From: Contact Centre (CRM) <contact@ribblevalley.gov.uk>
Sent: 20 May 2025 21:10
To: Planning
Subject: Planning Application Comments - 3/2025/0373 FS-Case-716316781

Planning Application Reference No.: 3/2025/0373

Address of Development: Ethos House, York St, Clitheroe

600mm x 600mm double sided illuminated projecting sign

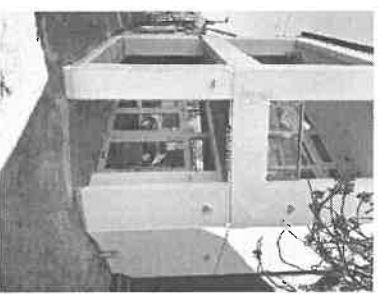
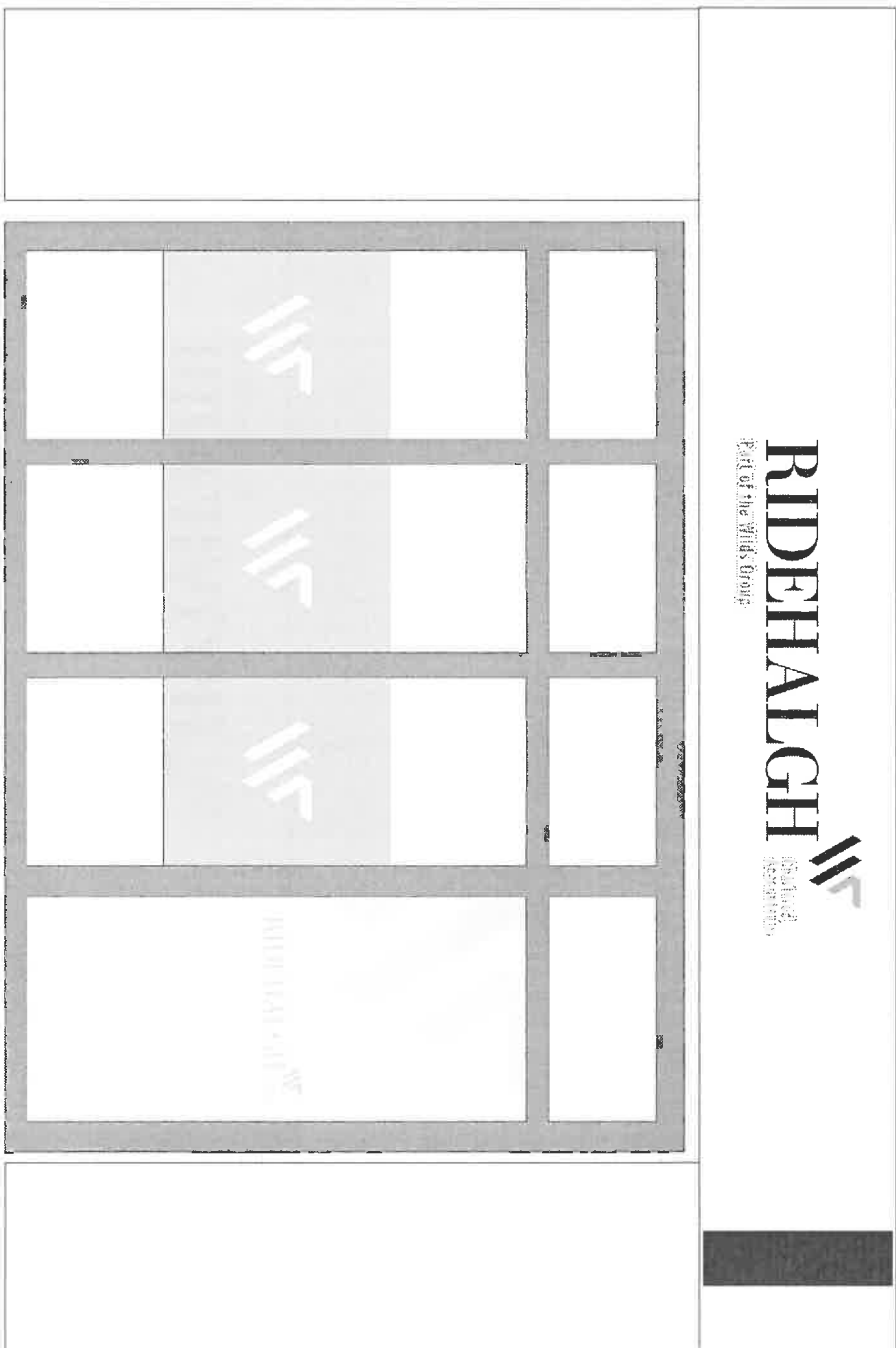
Comments: I submit comments on behalf of [REDACTED]. Whilst signage is important for the business/applicant, we feel that the internally illuminated projecting sign is not in keeping with the Conservation Area. Whilst the property itself is modern, it is close to listed buildings and buildings of merit in the Conservation Area.

It is noted in p12-13 of the Conservation Appraisal guidance that 'i) The sign is in keeping with the character of the shopfront and the area' - whilst it may not be out of keeping with the premises themselves, the nature of a internally illuminated sign is not in keeping with the character of the Conservation Area and may indeed set a precedent if approved. Also 'vii) Materials used should reflect the character in the Conservation Area', which due to the internally illuminated nature, cannot be said to be true for the proposed projecting signage here when considered as a part of the York St/Conservation Area.
